THE SANDSTONE PRECINCT

ACCESS REVIEW

Morris Goding Accessibility Consulting

14 October 2016

Accessible King Room (EB-L02-26)
Illustrative

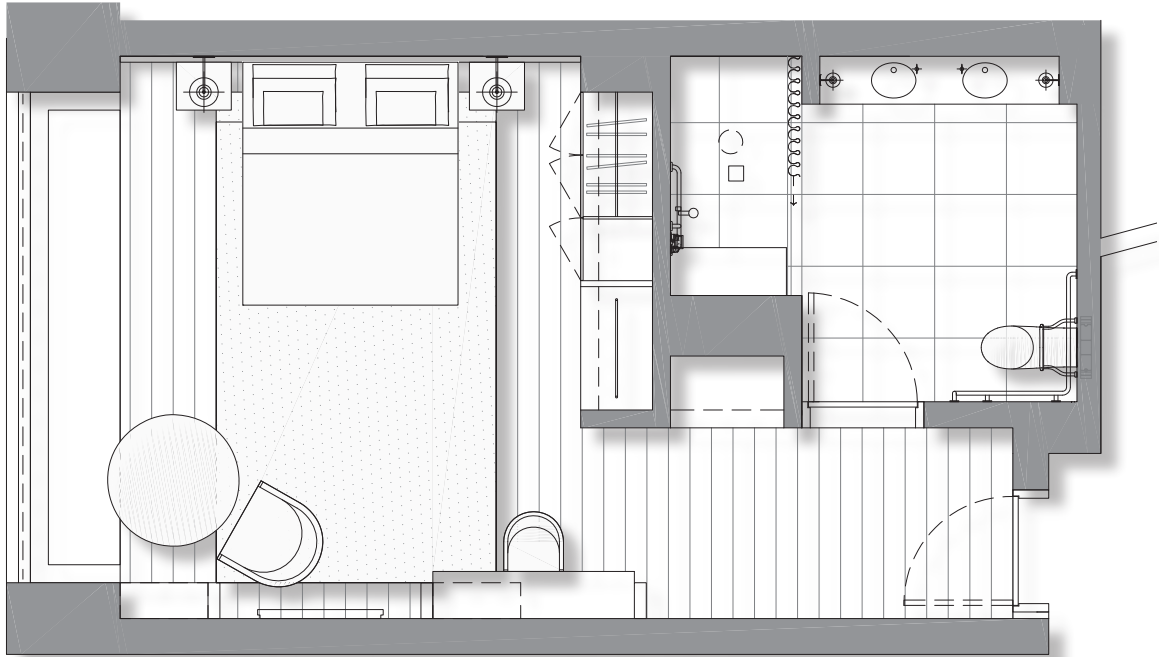
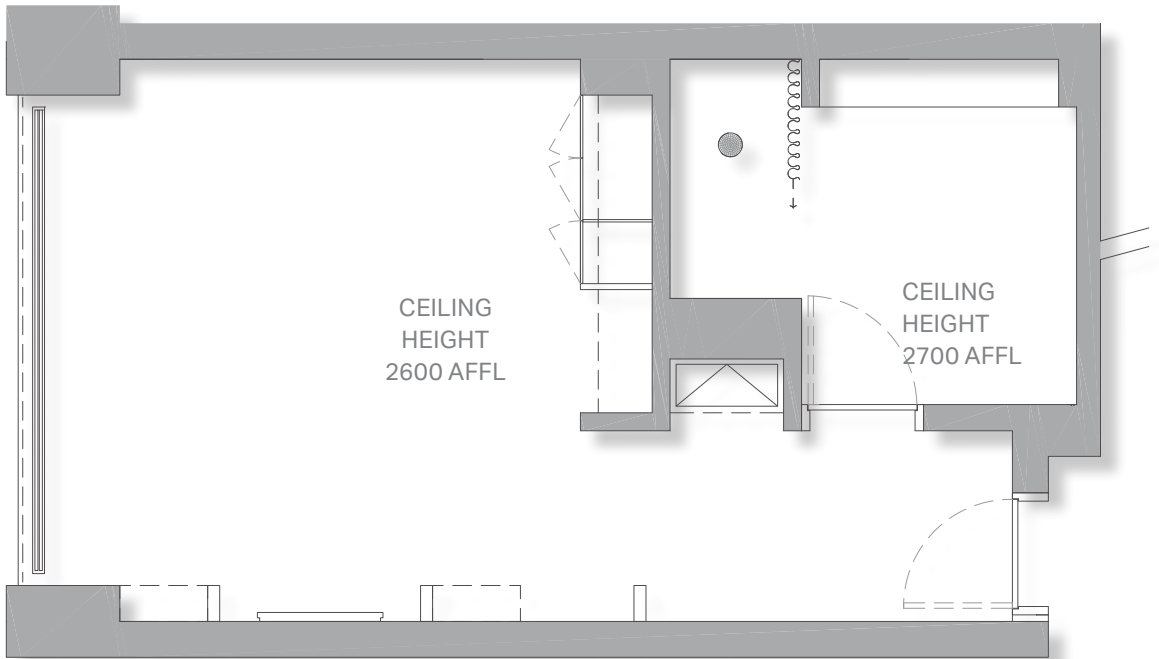
- (xvi) Ensure the ongoing design development of each accessible guest room is developed to meet AS1428.1:2009 circulation requirements and within accessible bathrooms includes a balance of LH and RH transfer pans across the total provision.
